**Babergh District Council:**  
**Addition to joint LIR for Bramford to Twinstead (EN020002) - Procedural Deadline 1**

**1. Introduction:**

**FIGURE 6.1**

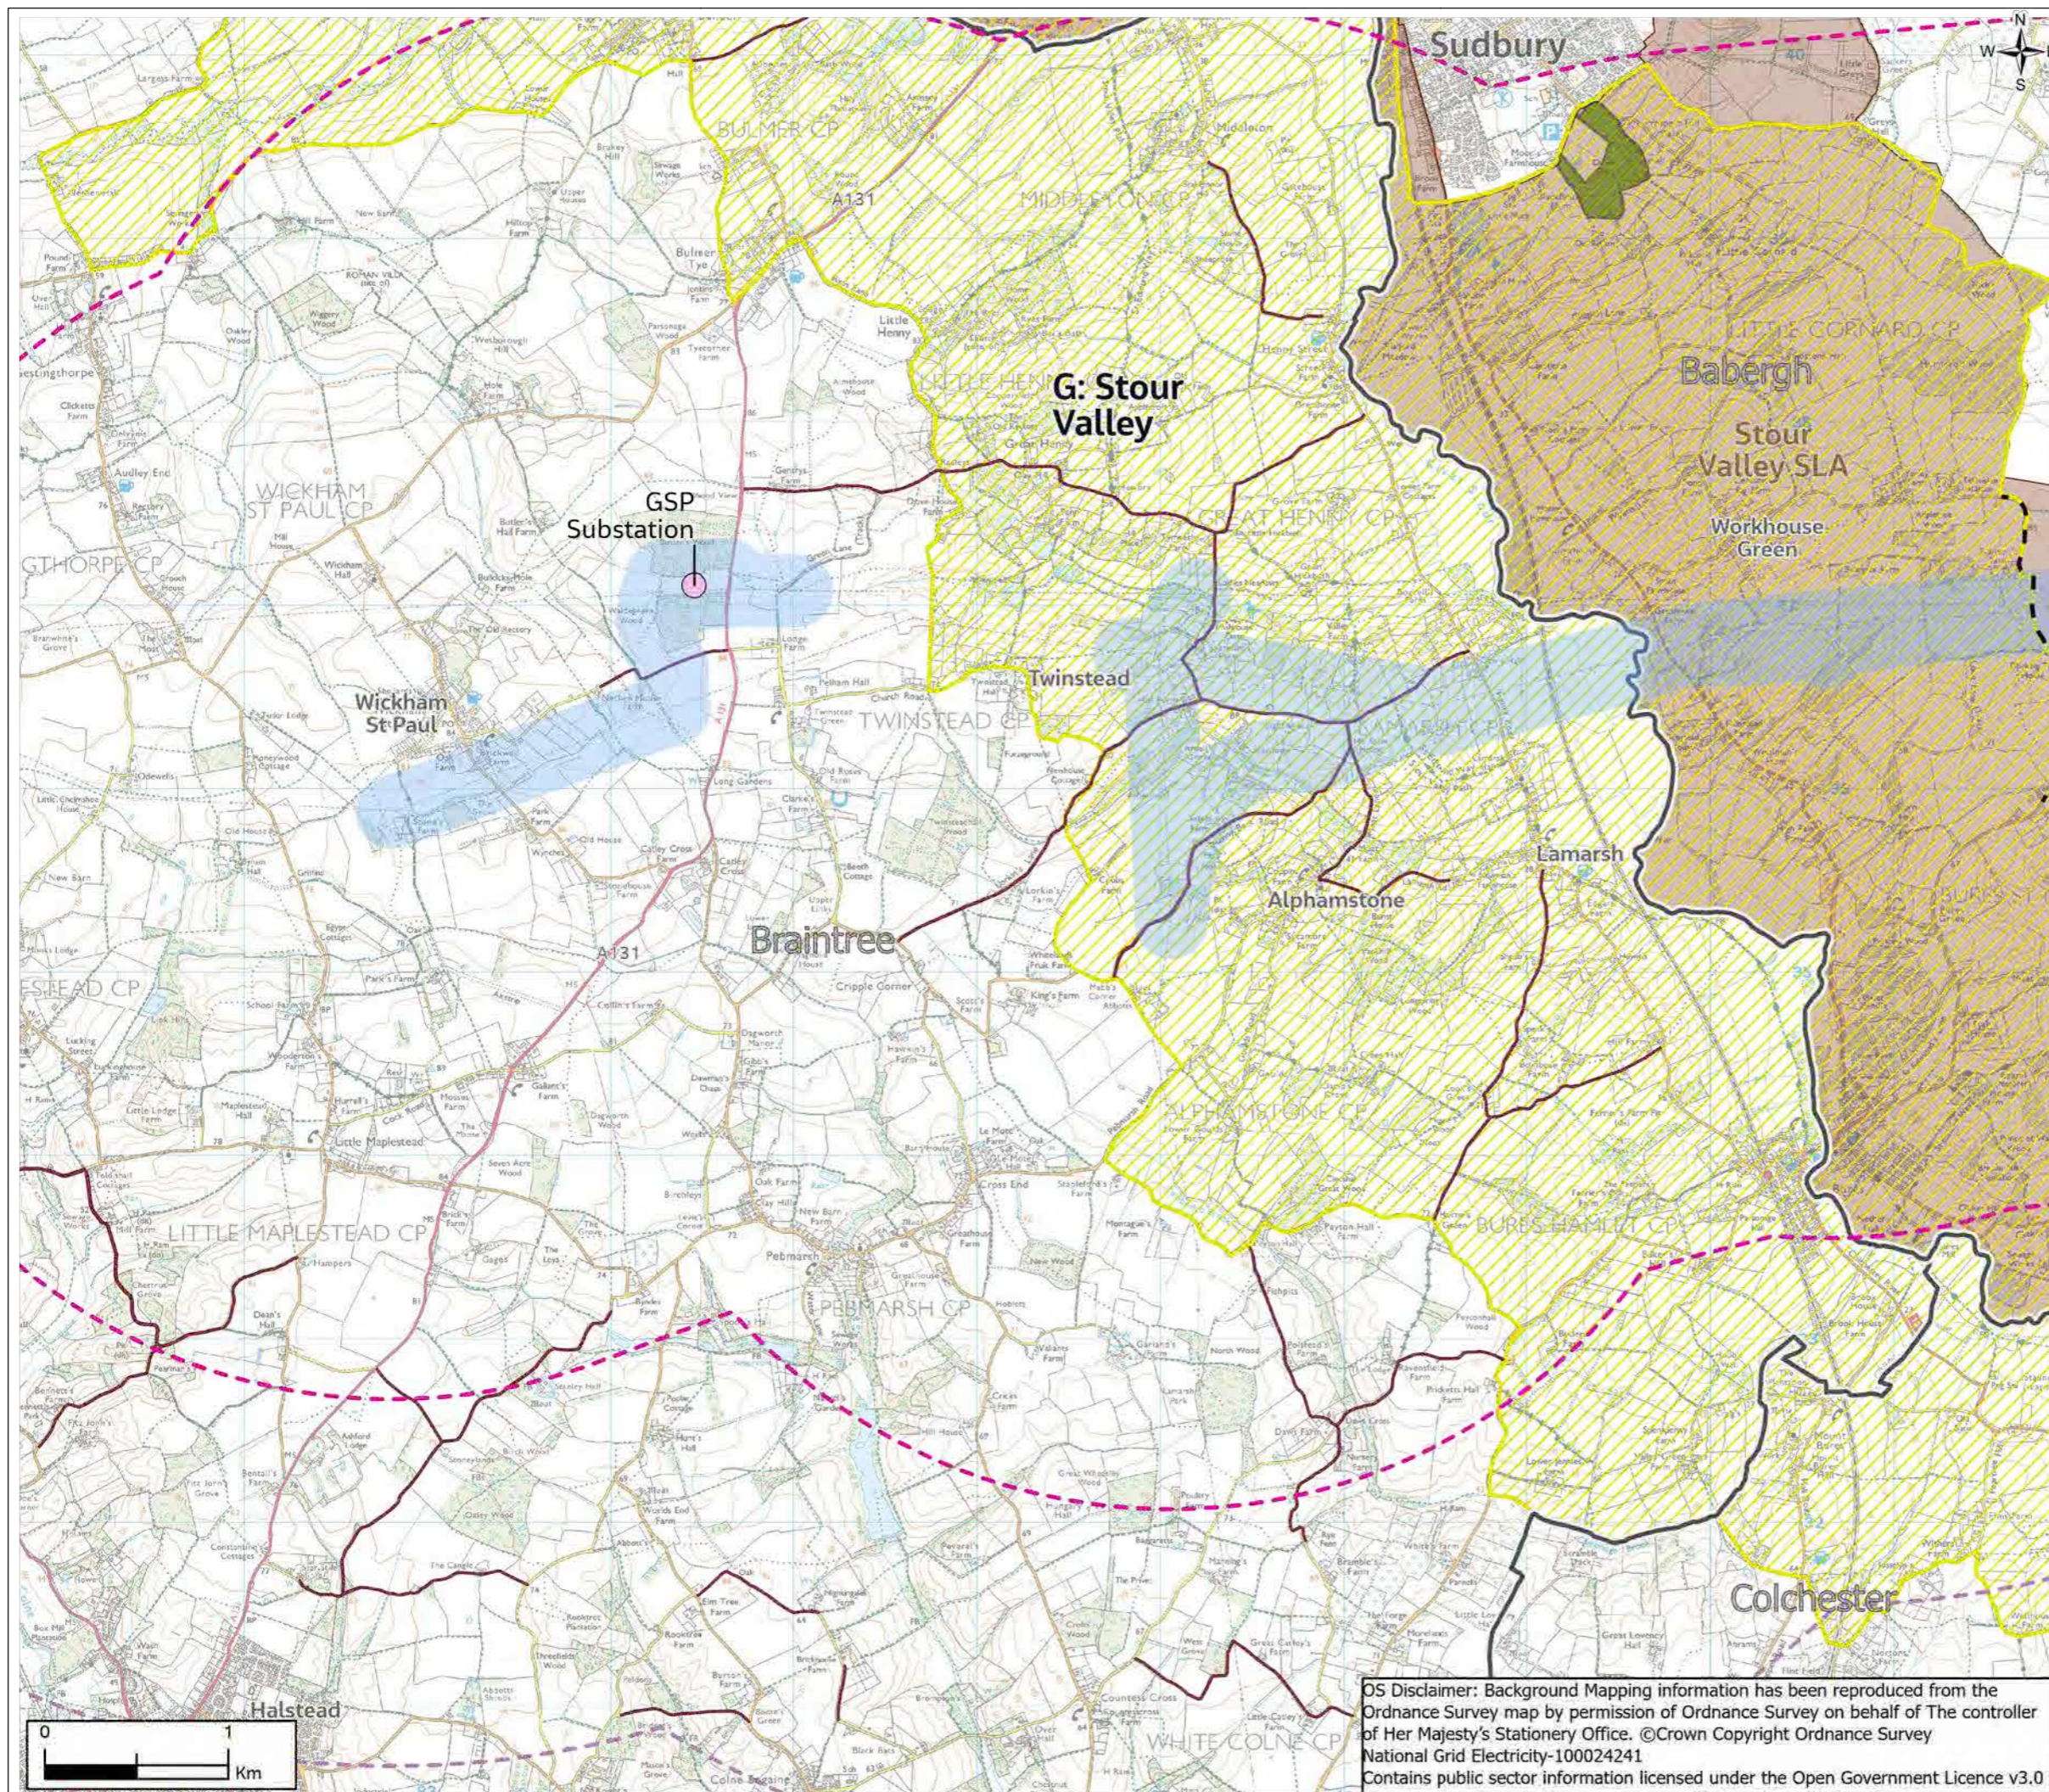
- 2.1 The proposed Stour Valley East Sealing End Compound lies within the Stour Valley Project Area and the Stour Valley Special Landscape Area, both identified for their scenic landscape character, sensitivity and value (*Figure 6.1: LVIA Study Area and Landscape Designations*). The Stour Valley Project Area has been assessed for its landscape value in the 'Valued Landscape Assessment Stour Valley Project' in March 2020 by Alison Farmer Associates (Available at Appendix A to this submission).
